## Response to Planning application from Hertfordshire County Council (T and CP GDP Order 2015)

District ref: 6/2023/1099/PN15  
HCC ref: WH/16930/2023  
HCC received: 14 July 2023  
Area manager: Manjinder Sehmi  
Case officer: Gideon Gasinu

Hatfield Avenue Hatfield Business Park Hatfield AL10 9FY

Proposed telecommunications installation: Proposed 15.0m Phase 8 Monopole and associated ancillary works

Title: **211 VIS SPLAY PLAN**

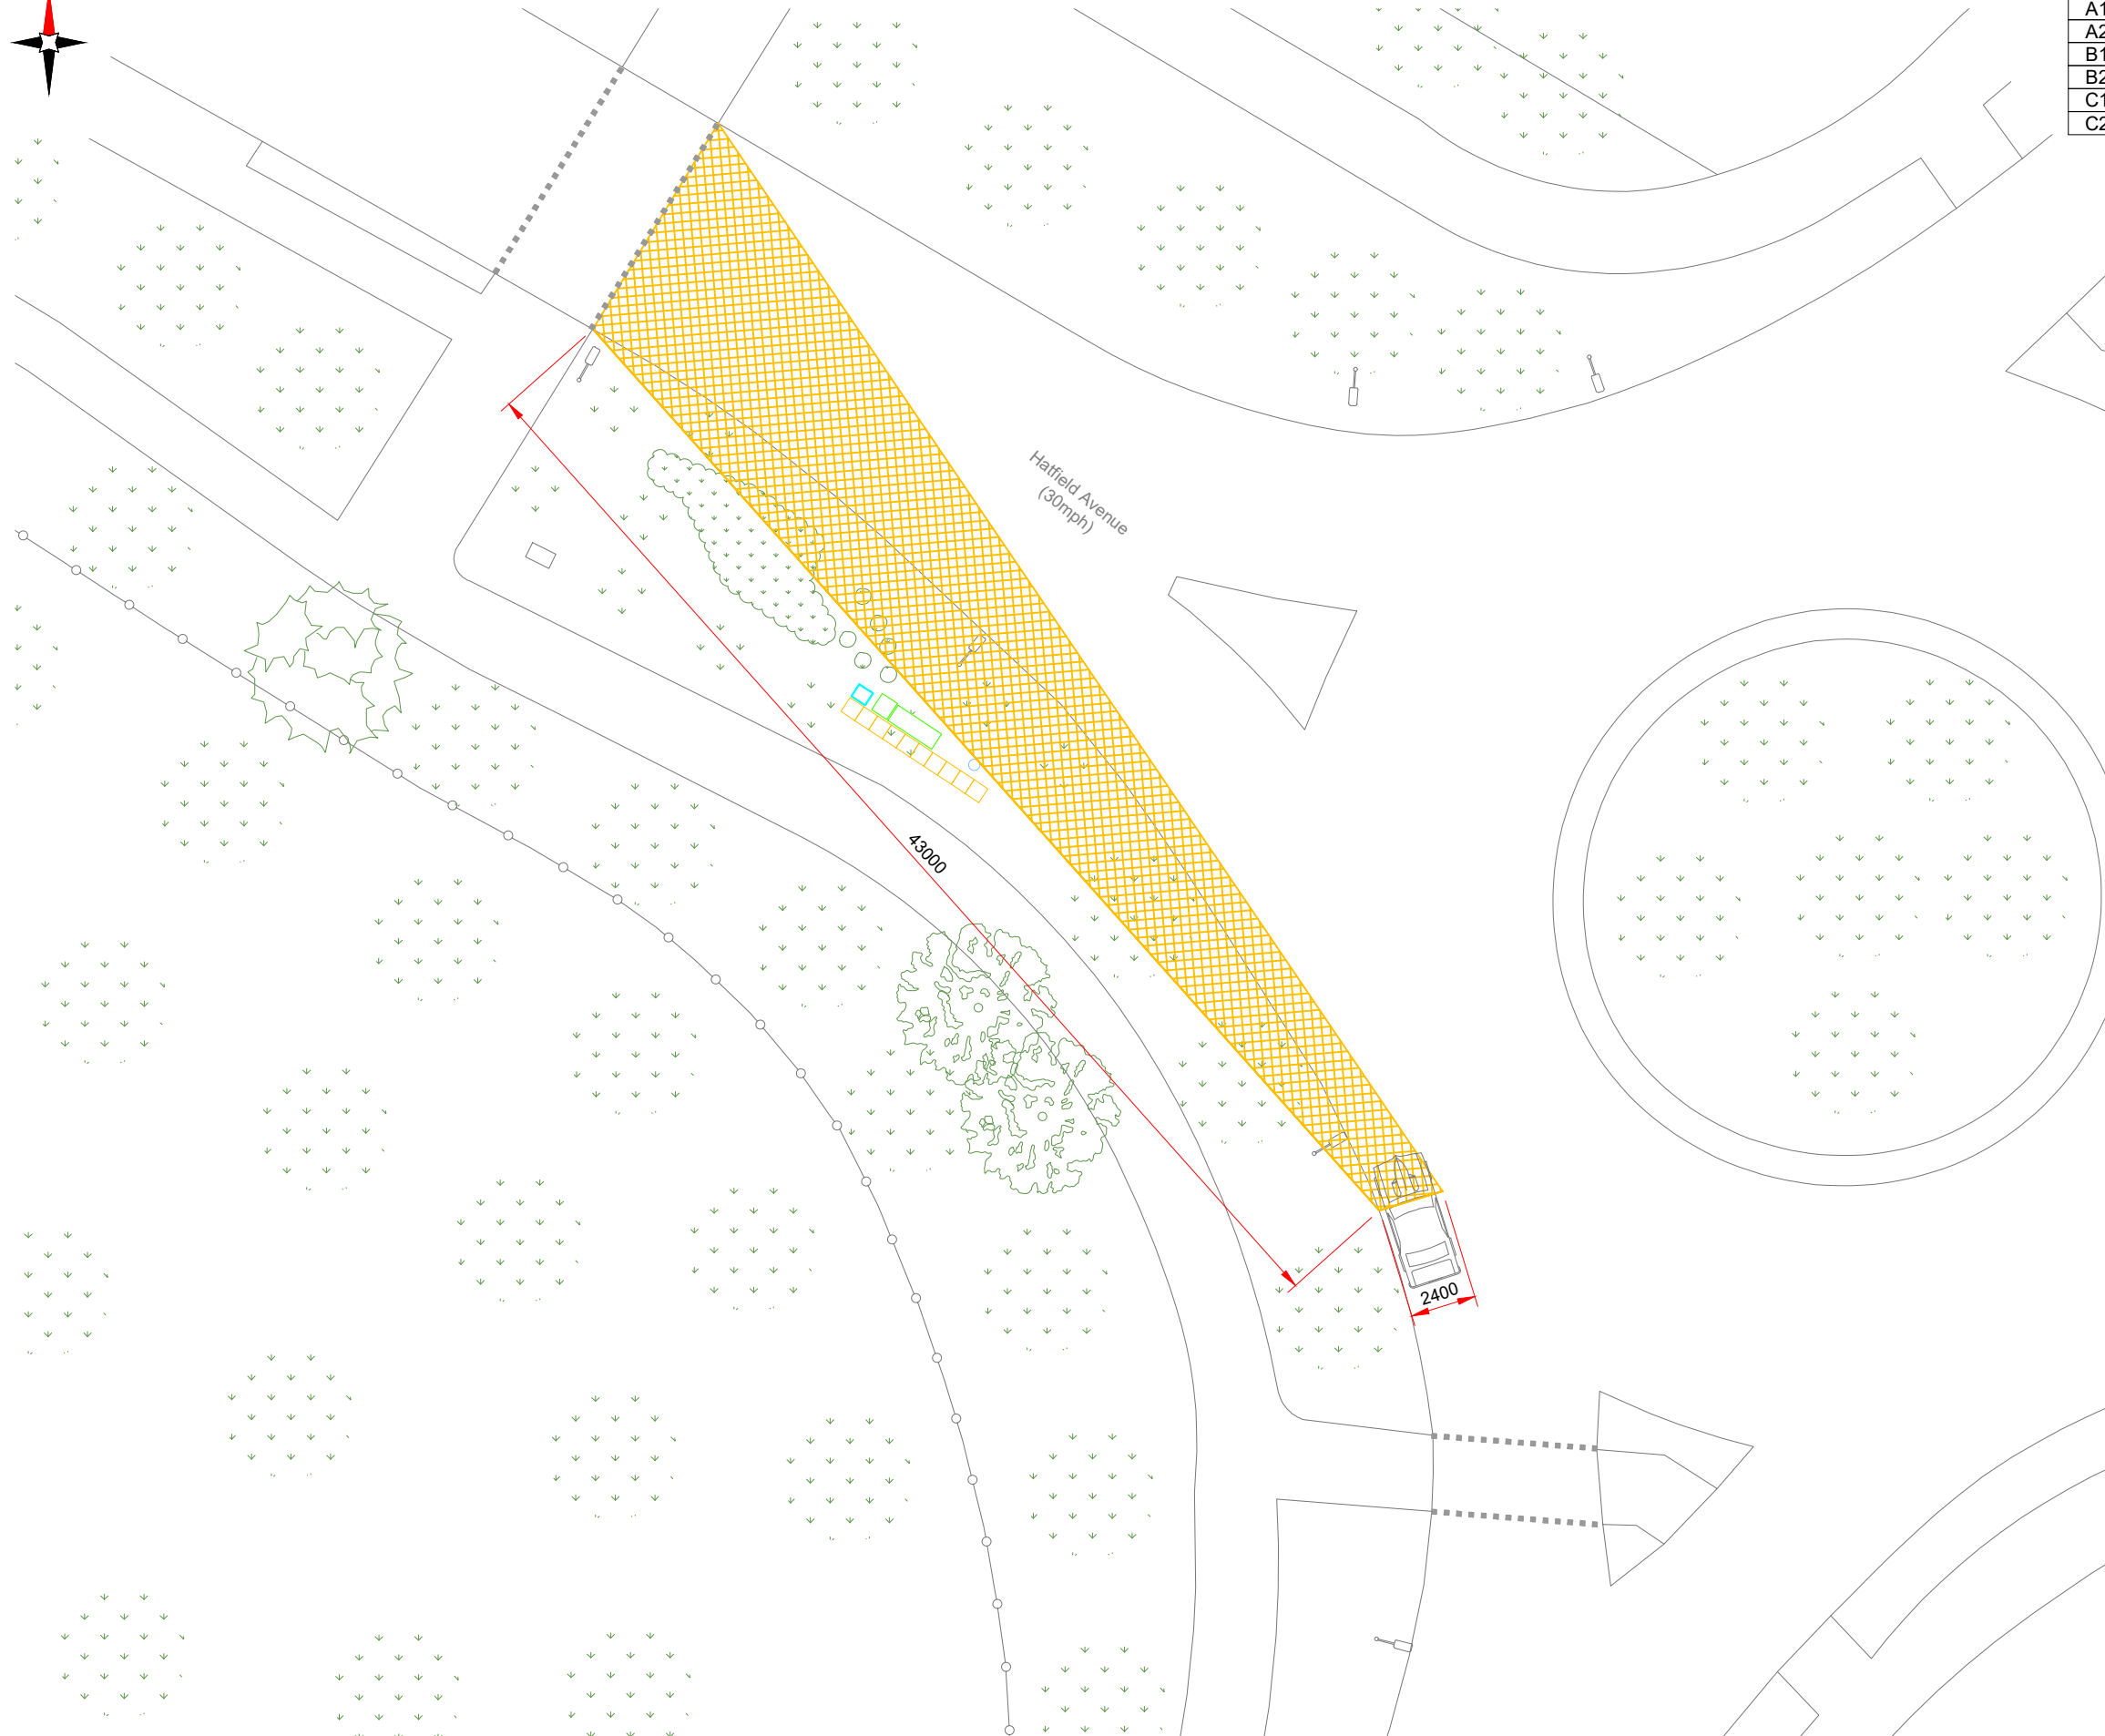
This application is for a consultation following refusal on the grounds of insufficient information. The Highway Authority notes the submission of additional information WEH22203\_M002 Rev B which shows visibility splay information.

Following the previous objection in June and July 2023, the applicant has submitted new visibility drawings (WEH22203\_M002 Rev B) which have been reviewed and considered acceptable.
